## Response to CDC Arboricultural Officer Comments

### Arboricultural impact assessment.

### Arboricultural method statement.

### Ancient woodland.

Registered office: 01285 740427 - www.edp-uk.co.uk - info@edp-uk.co.uk

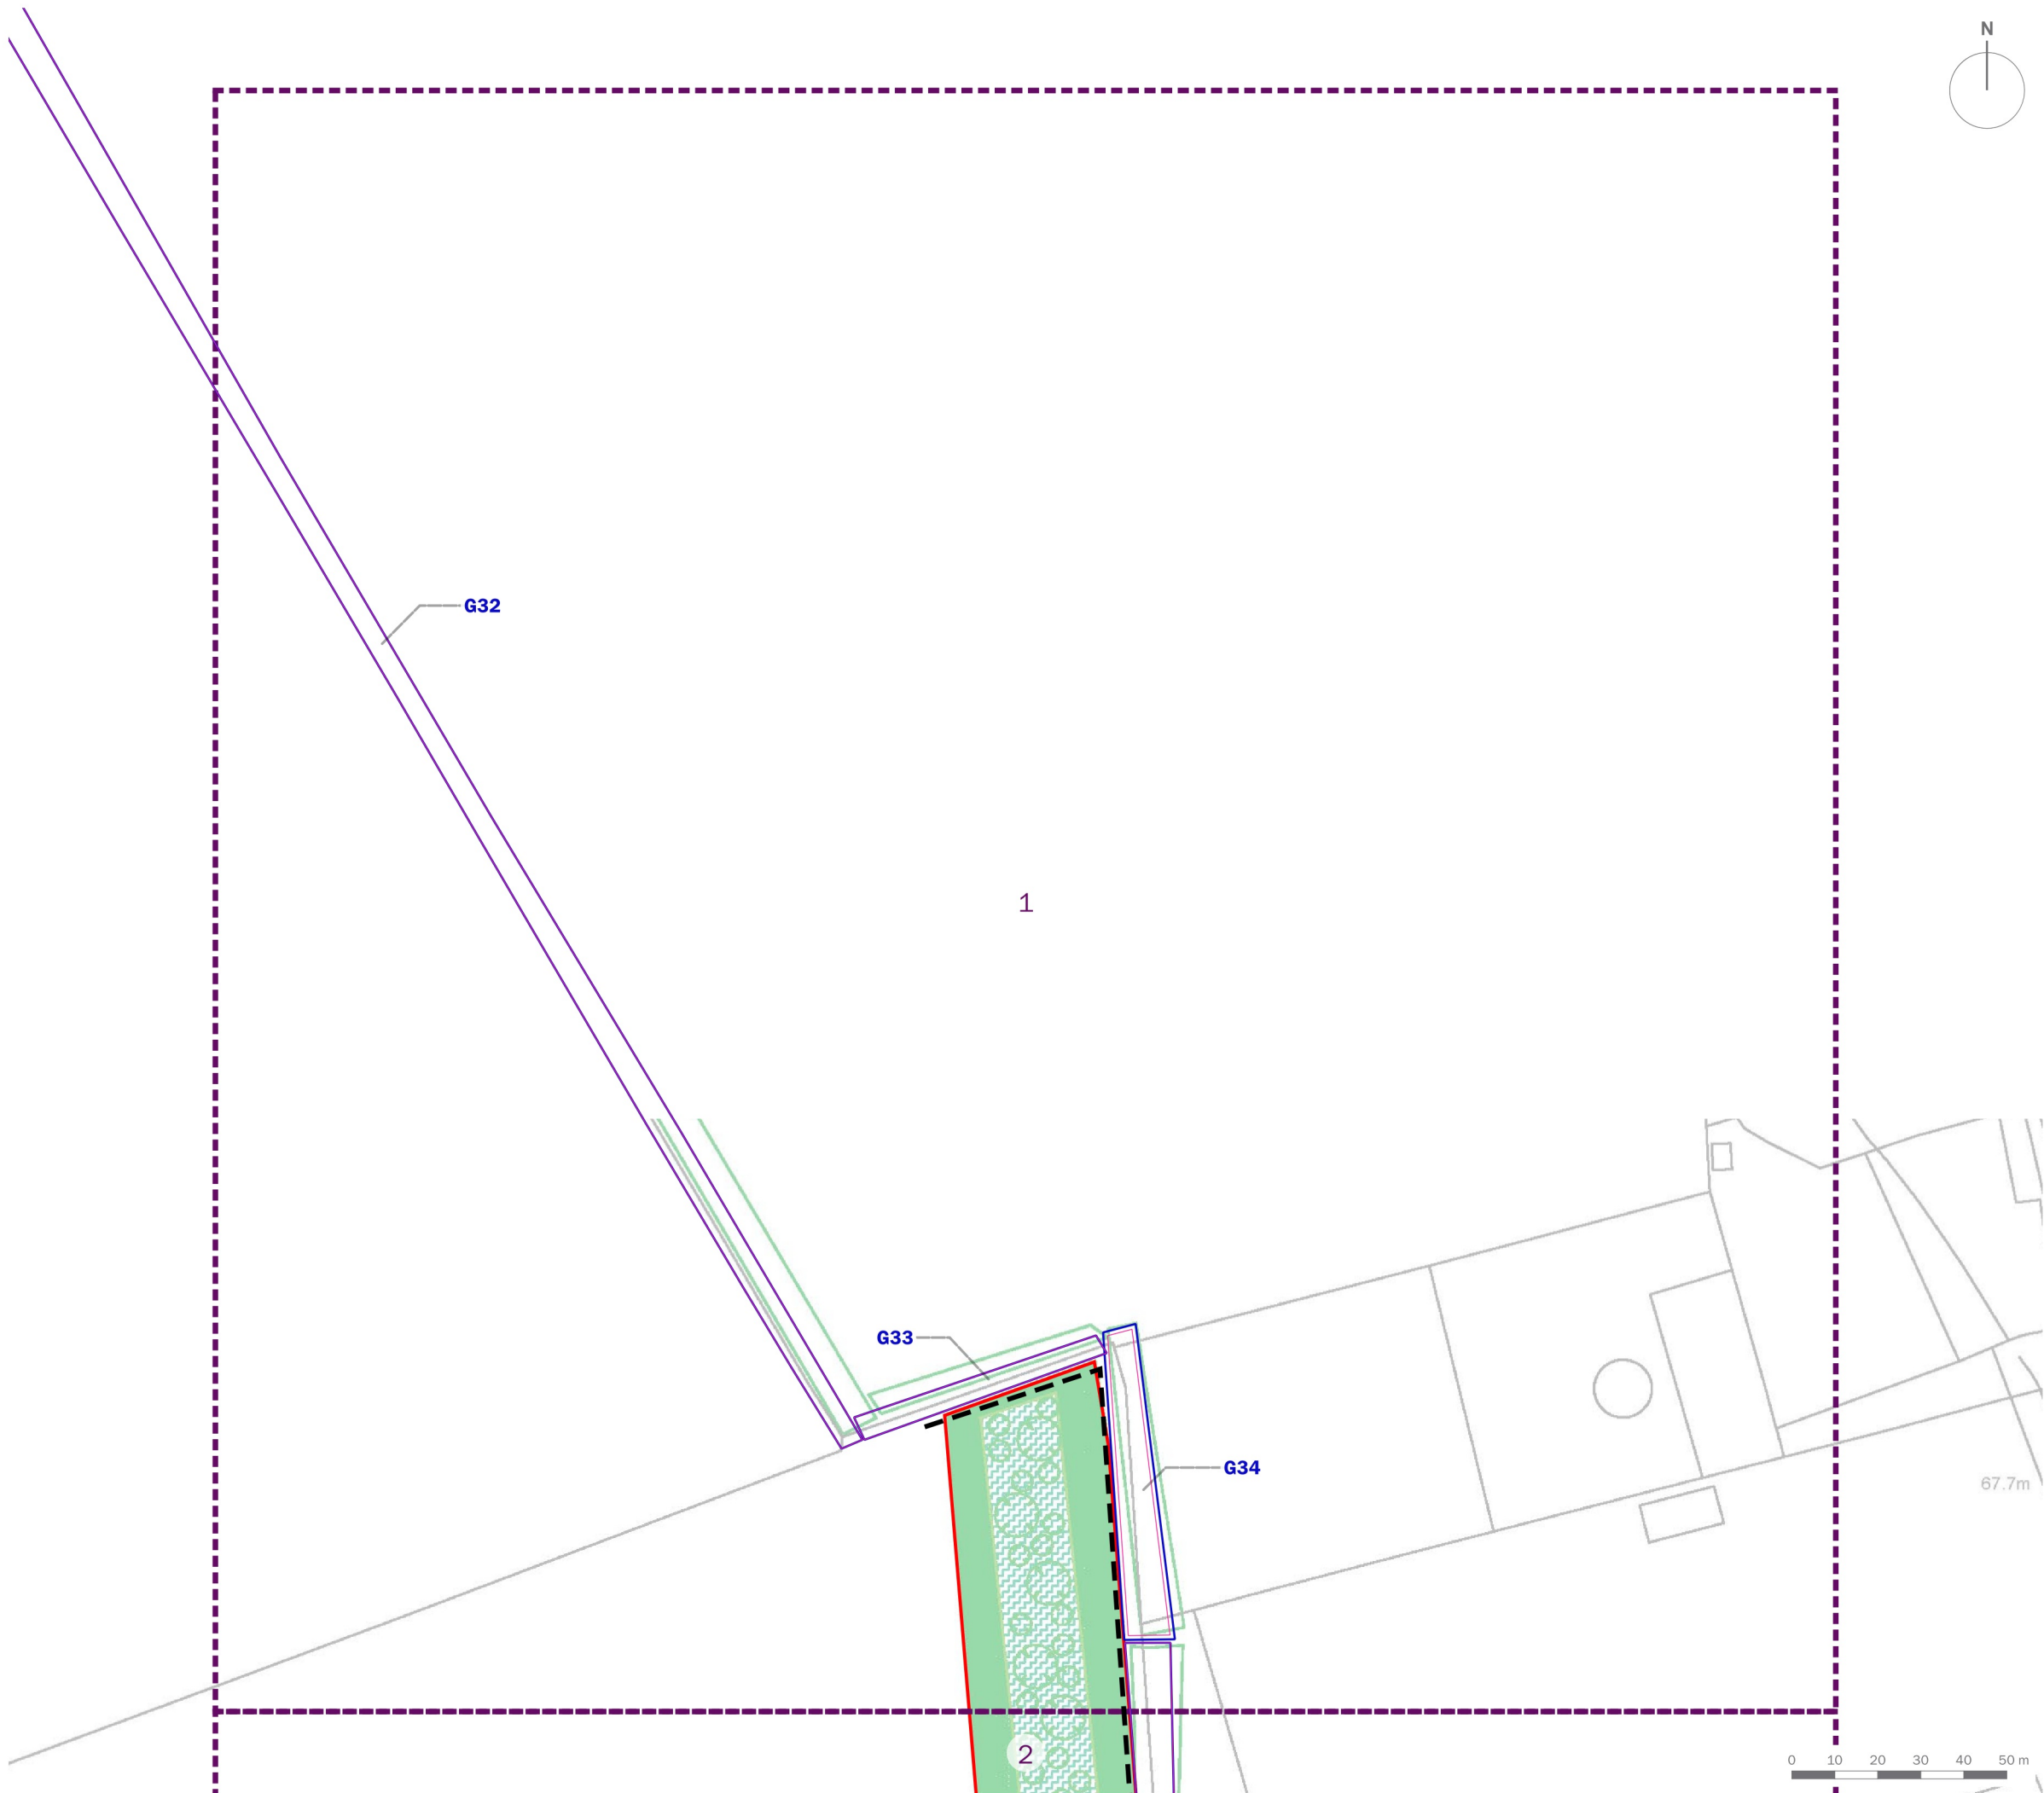
- Confirm justification for T37 removal.
  - T37 is being removed to enable the construction of a bund around the eastern portion of the site. Please refer to the Tree Protection Plan contained within the updated Arboricultural Impact Assessment (June 2022).

- Full AMS/TPP plan including access.
  - The Tree Retention Removal Plan has been revised to a Tree Protection Plan within the updated Arboricultural Impact Assessment (June 2022). Furthermore, protective fencing will be erected within the redline boundary in areas where development should be excluded from RPA's.
